# Rezoning Transportation Analysis

Petition Number: 2020-109

## Revision Log:

| Date     | Description        |
|----------|--------------------|
| 11-30-20 | Third Review (LJ)  |

EX01-REZONING PLAN

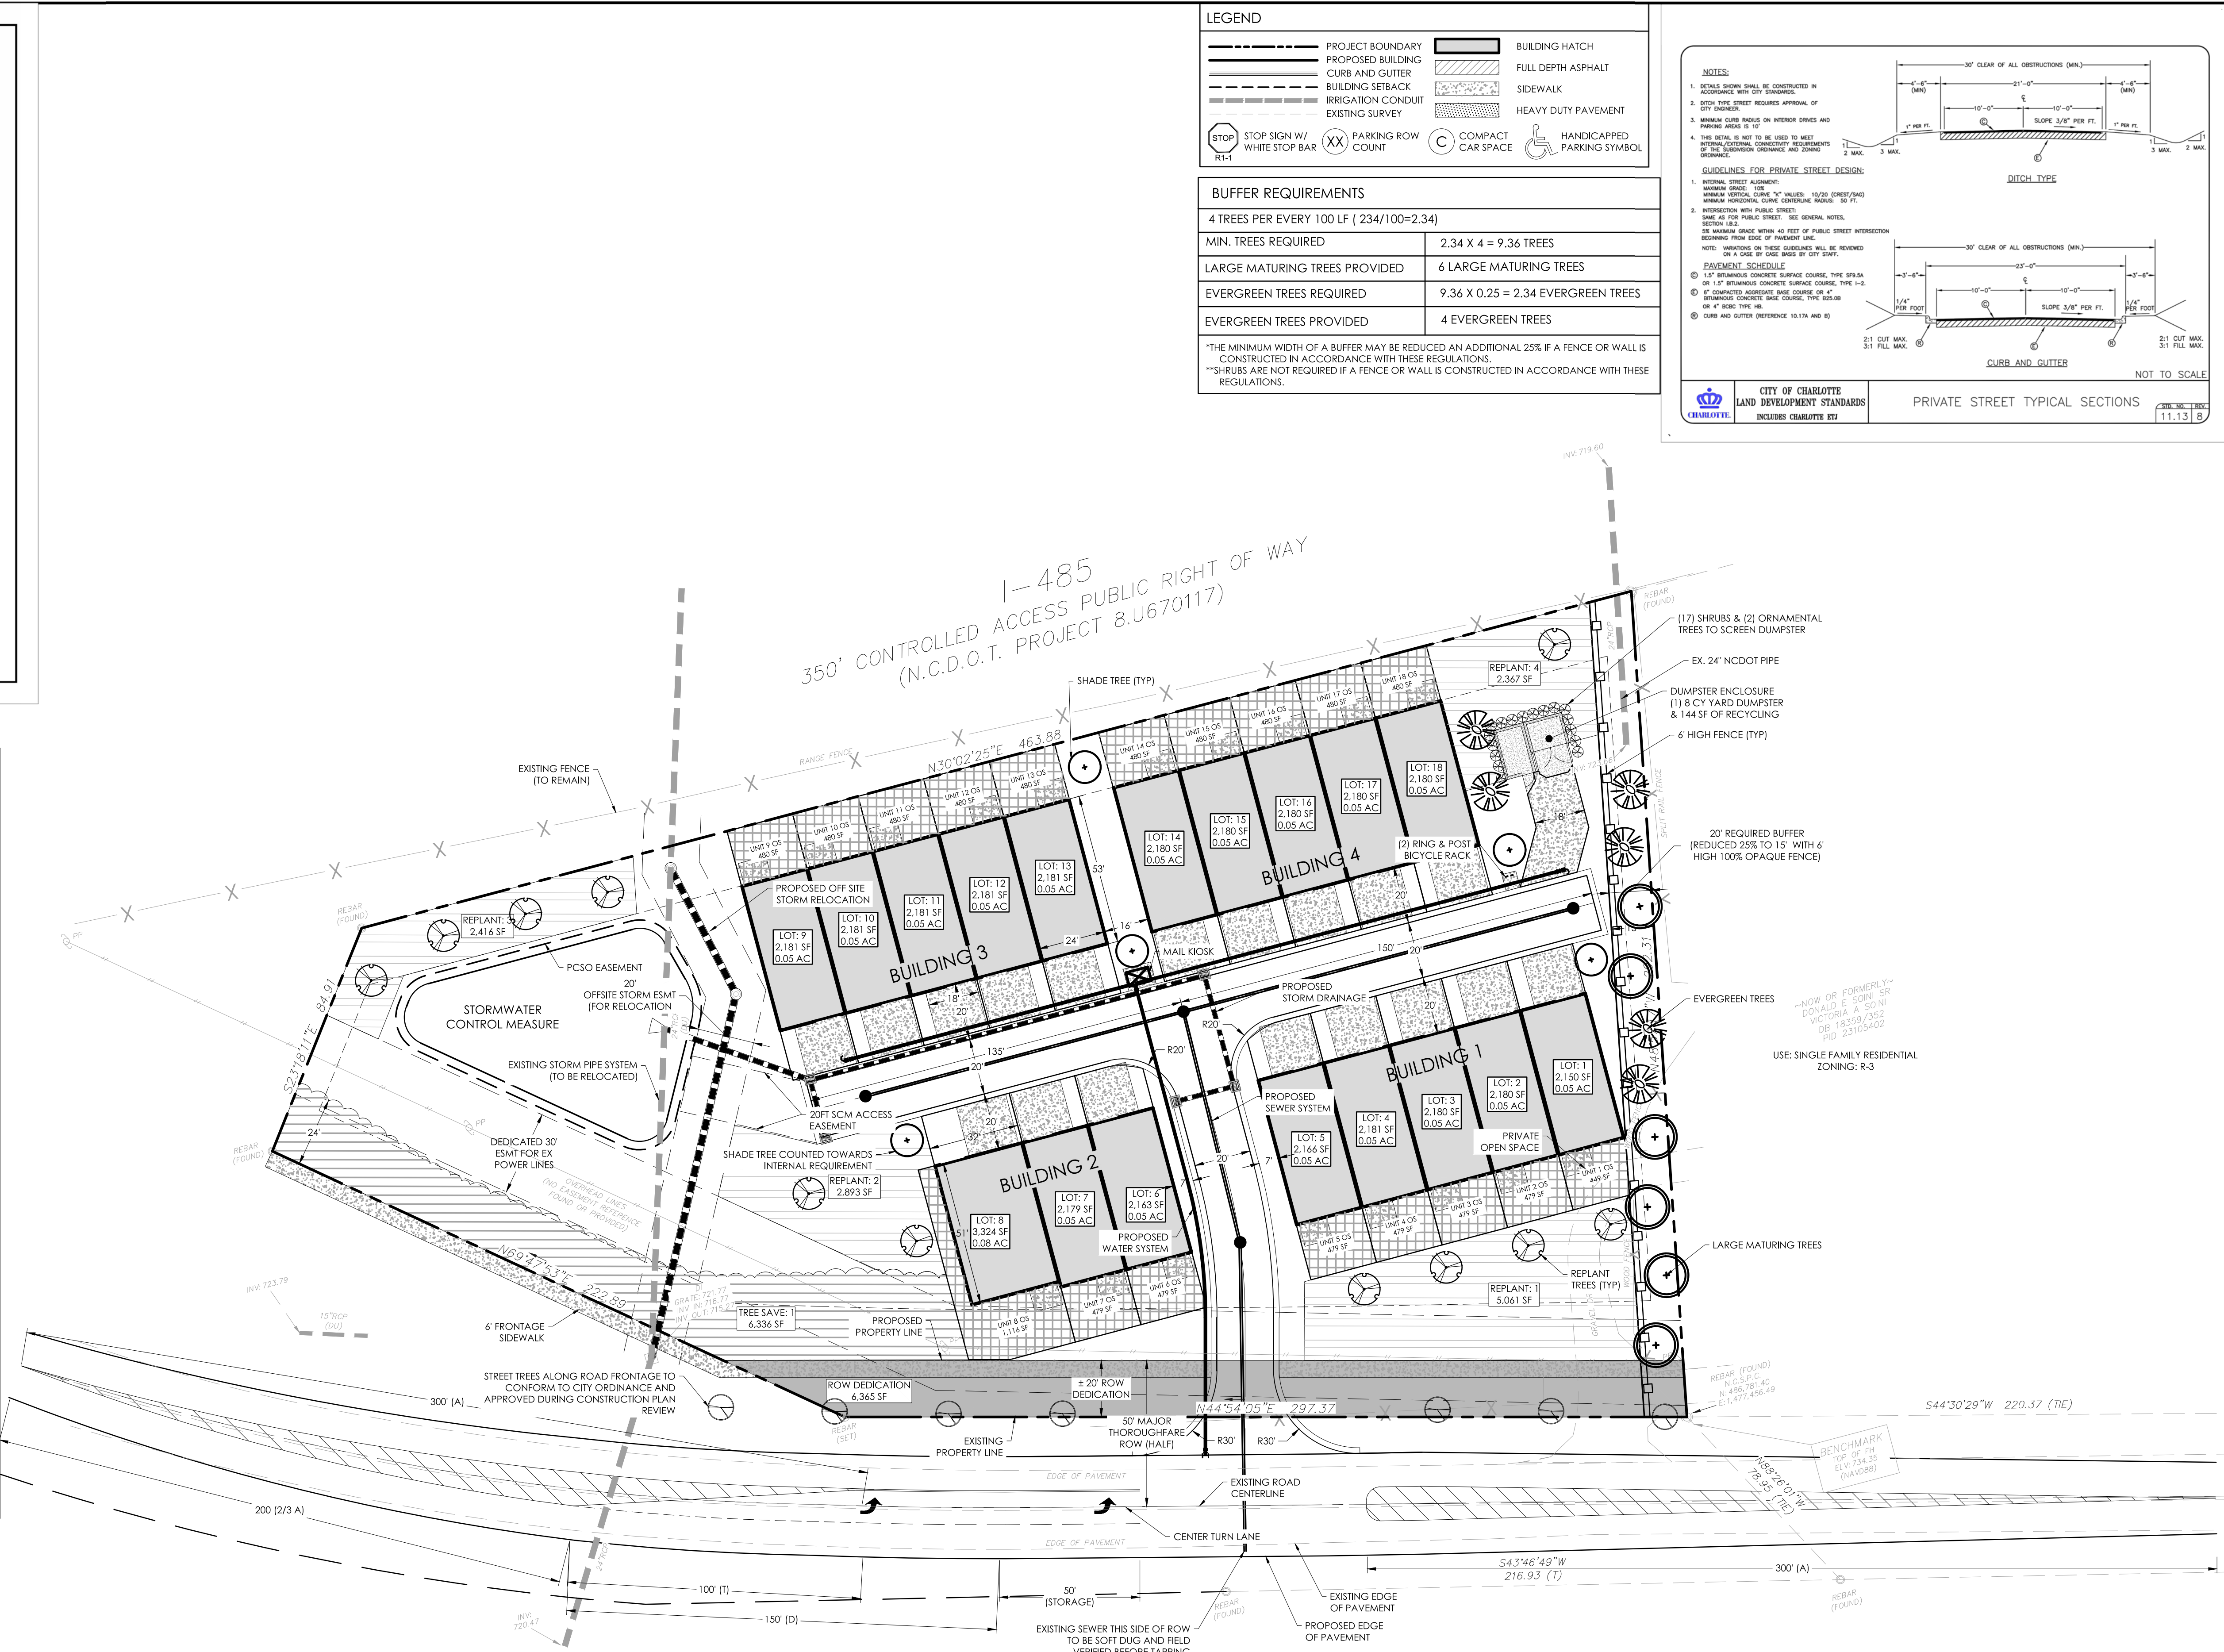
**McKee Road (NCDOT):** The future location of back of curb and gutter is 30' from the McKee Road centerline. The curb and gutter needs to be labeled and dimensioned from the road centerline to the back of curb on the site plan.

3. The site plan and conditional note(s) need to include an 8-foot planting strip on McKee Road per Chapter 20/Chapter 19. CDOT requests a 12-ft Multi Use Path in lieu of the required 6-foot sidewalk per the Charlotte BIKE Policy (primarily due to land use context and lack of frequent driveways). Both items need to be labeled and dimensioned from the back of curb and gutter and road centerline on the site plan.

Begin the Multi Use Path where the property line changes direction and runs parallel with McKee Road.

4. Pedestrian sight triangles (NCDOT 10'x70') at the McKee Road driveway connection need to be reflected on the site plan. Label all roadways as private streets, where appropriate.
5. Provide ISD along McKee Road for driveway, both horizontal and vertical included to show standard meets NCDOT standards.
6. (Revised 10/19/20): Petitioner to relocate the inner crosswalk to alleviate the diagonal crosswalk at the 3-legged intersection.

7. (Revised 10/19/20): Petitioner to provide a 100' driveway stem from NCDOT ROW line, as per NCDOT standards.

8. Add a note specifying all transportation improvements will be approved and constructed before the site's first building certificate of occupancy is issued. The petitioner may phase transportation improvements if said improvements and phasing are explicitly described in site plan notes.
9. A site plan note(s) specifying dedication and fee simple conveyance of all rights-of-way to the City before the site's first building certificate of occupancy is issued is needed. CDOT requests rights-of-way set at 2' behind back of sidewalk where feasible.
